Addendum No. 1

RE: Contract # C204568

WBS # 15BPR.46

BRIDGE #270012 OVER ROANOKE SOUND ON US-64

DECK SURFACE REPAIR
SPANS 12-21

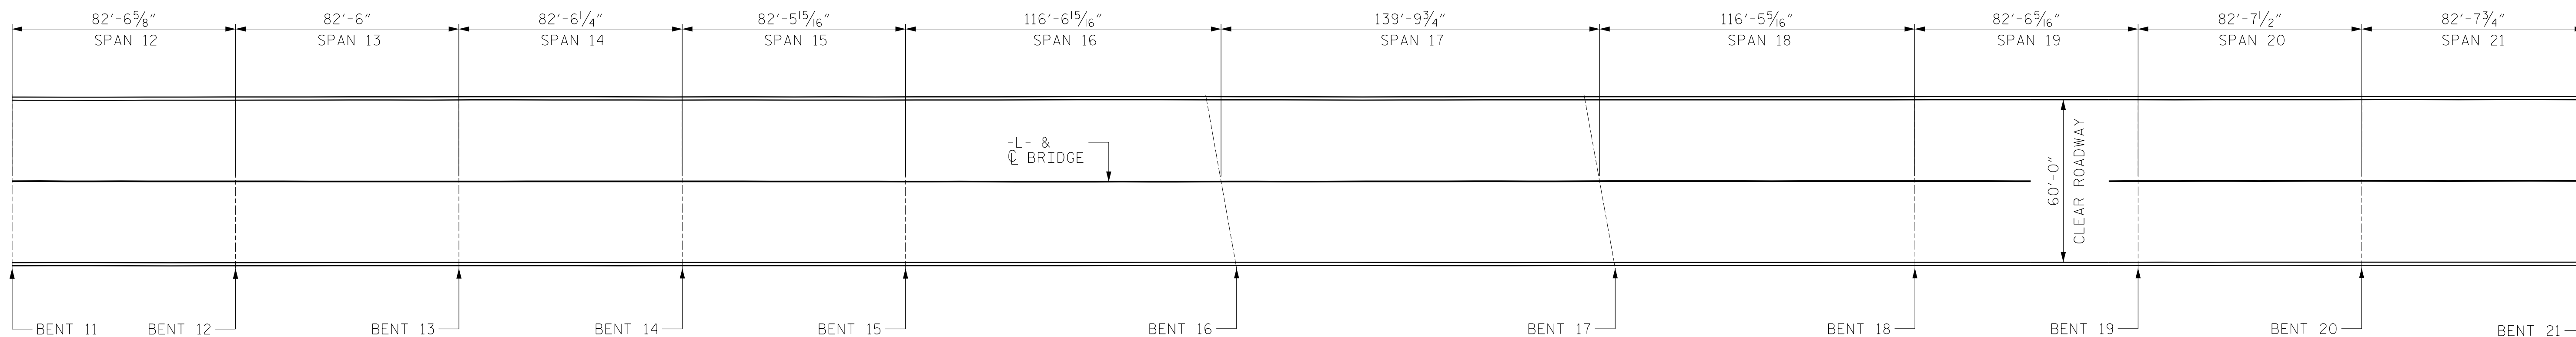
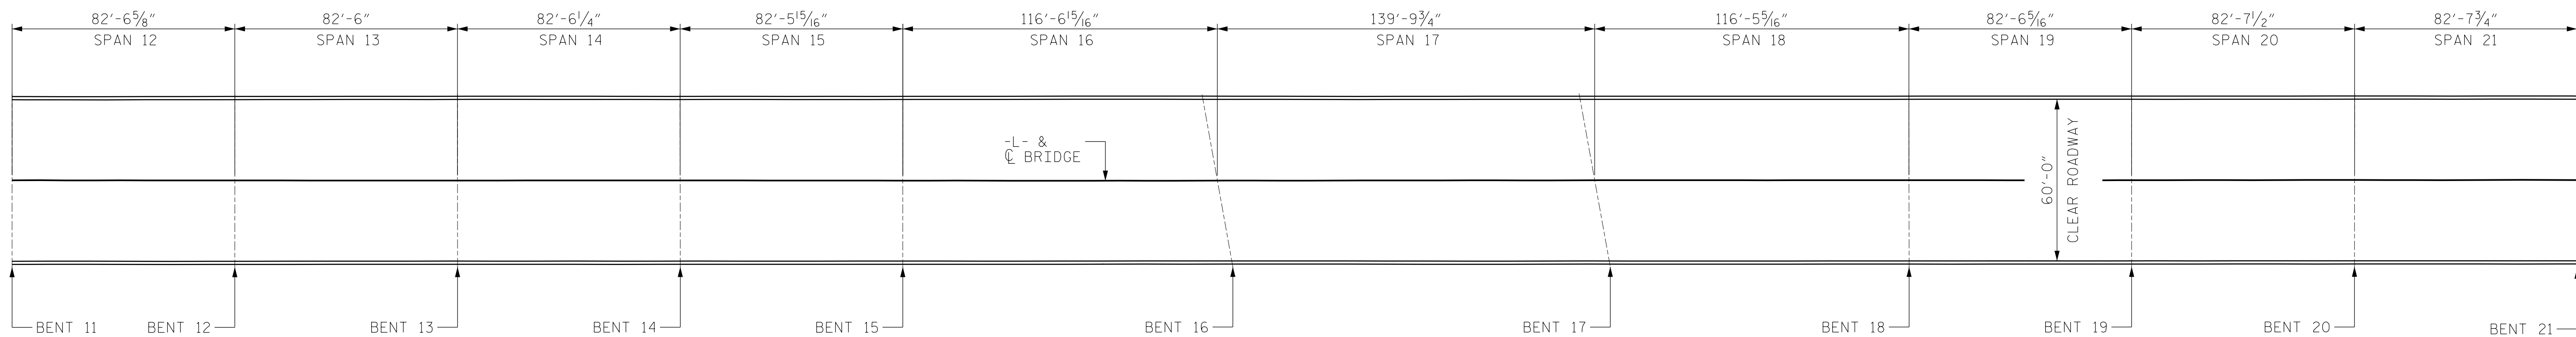
Sheet No.	Revision
S-12	Note 4 was revised. References to dimensions A,B,C,D, and E were removed.
S-13 thru S-18	All references to Class II deck repair have been removed from the Deck Surface repair sheets.
